Your Ref :
Our Ref : LU/317/18/NMA

Section 96A of the Town & Country Planning Act 1990 (as amended)
Town and Country Planning (Development Management Procedure) (England) Order 2015 (as amended) - Article 10
Applicaton for a non-material amendment following the grant of LU/121/17/RES relating to new site layout plan (bricks).
Toddington Lane, Littlehampton, ,

Littlehampton Phase 2
Outer Central Core

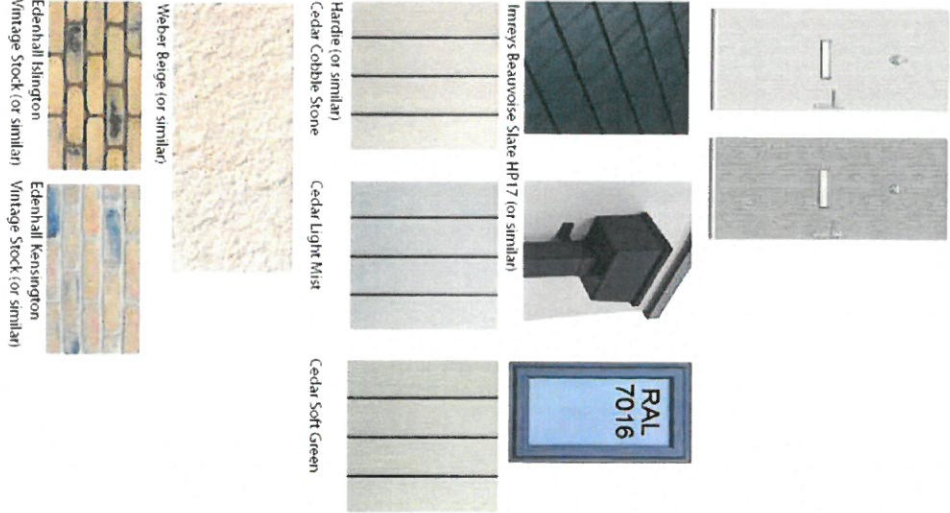
The reasons that the proposal has been accepted as Non-Material Amendments is because they comprise a brick change replacing the Edenhall Dolomite Cream Brick with the Brickworks Langold Buff stock brick, both of which are almost identical ,and it can therefore be considered under section 96A of the Town and Country Planning Act 1990.

Please note that Drawing Number 543_PL_SITE LAYOUT_107 Rev G now forms part of the approved planning drawings and supersedes "Drawing Number 543_PL_SITE LAYOUT_107 Rev F".

From the information submitted I am prepared to take the alteration as a Non Material Minor Amendment to the reserved matters approval LU/121/17/RES.
